Rezoning Transportation Analysis
Petition Number: Insert Zoning Petition #2022-017
General Location Identifier: 03301203

Revision Log:

Date	Description
06-23-22	First Review (PDM)

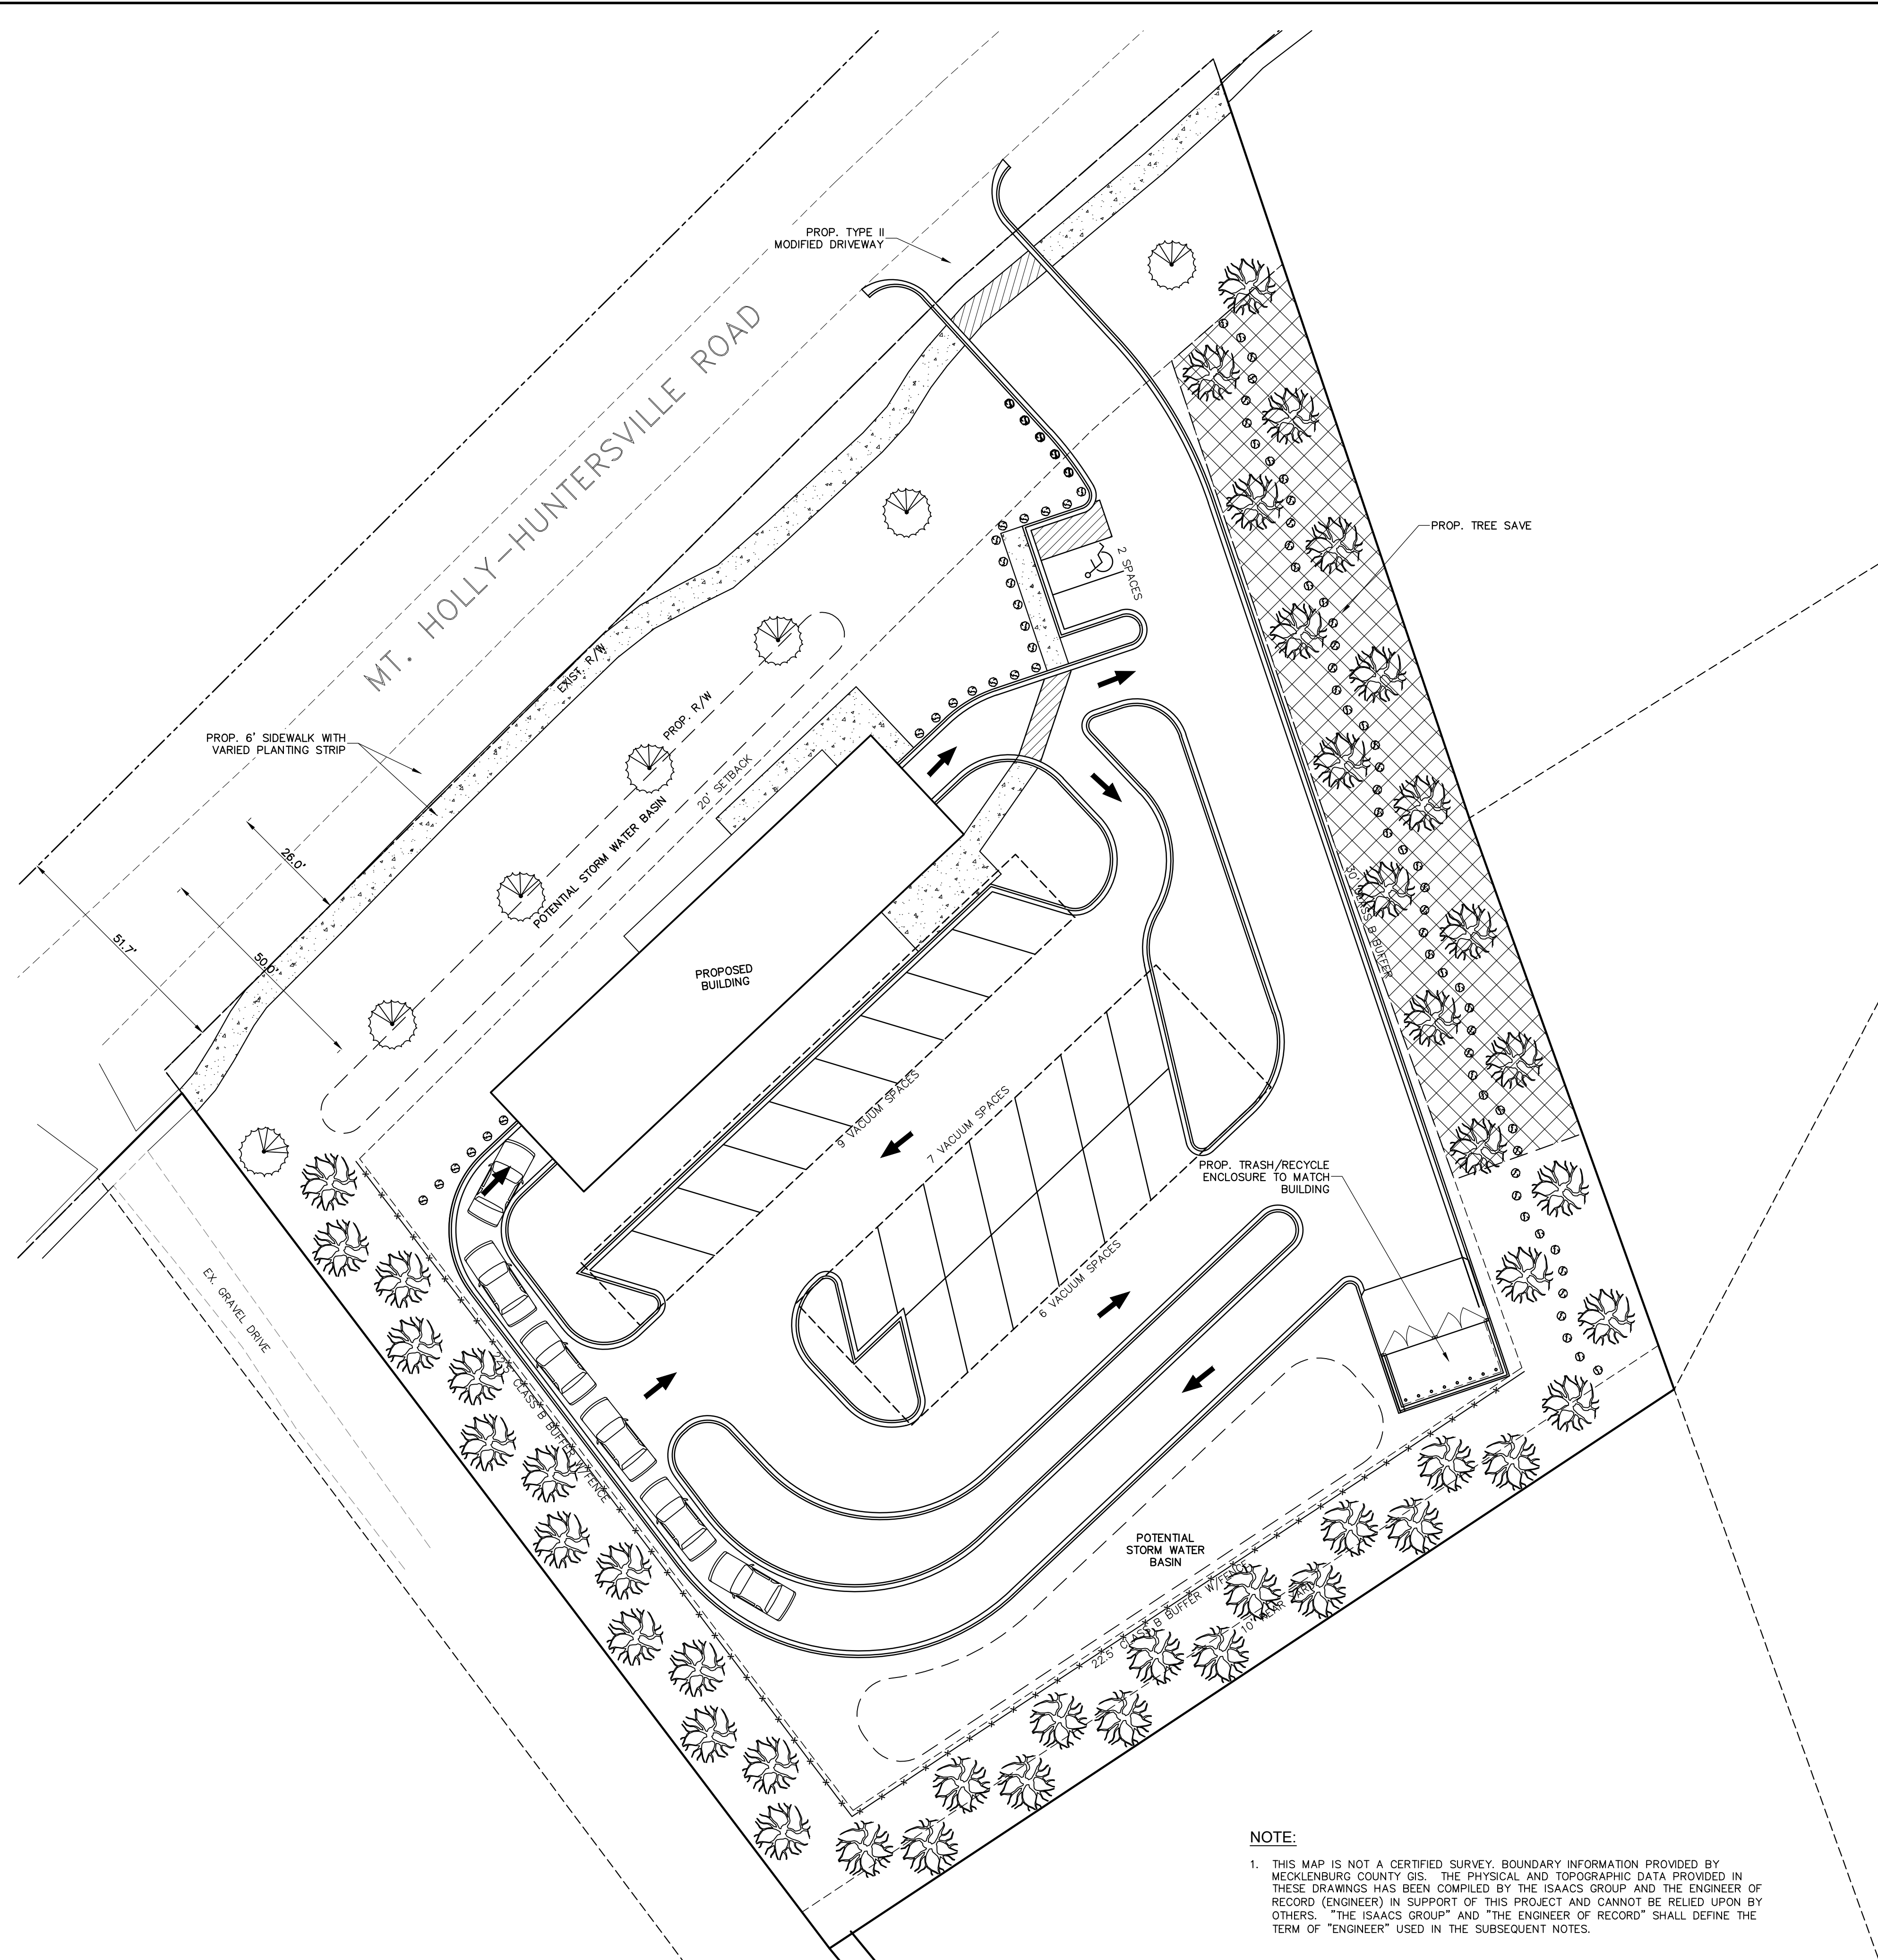
2. Revise site plan and conditional note(s) to commit to dedicate 50-feet of right-of-way from the road centerline. The site plan shall label and dimension the right-of-way from the road centerline. Show and label the proposed ROW.

3. Revise site plan and conditional note(s) to commit to installing curb and gutter along the property frontage per Chapter 19. The back of curb shall be located 30-feet from the centerline of the roadway.

4. Site plan and conditional note(s) revisions are needed to commit to construct bicycle facilities a 12-foot multi-use path to meet the City Charlotte BIKE Policy. The multi-use path shall be located behind an 8-foot planting strip.

5. Per coordination with NCDOT revise site plan to provide a driveway stem with a minimum of 100-feet measured from the proposed right-of-way. No parking shall be located within the protected driveway stem.

6. Remove "if applicable" from the site plan note specifying that all transportation improvements will be approved and constructed before the site's first building certificate of occupancy is issued. The petitioner may phase transportation improvements if said improvements and phasing are explicitly described in site plan notes.

7. Add conditional note "All public roadway improvements will be subject to the standards and criteria of CDOT and NCDOT, as applicable, to the roadway improvements within their respective road system authority. It is understood that such improvements may be undertaken by the Petitioner on its own or in conjunction with other development or roadway projects taking place within the broad northwestern Mecklenburg area, by way of a private/public partnership effort or other public sector project support."
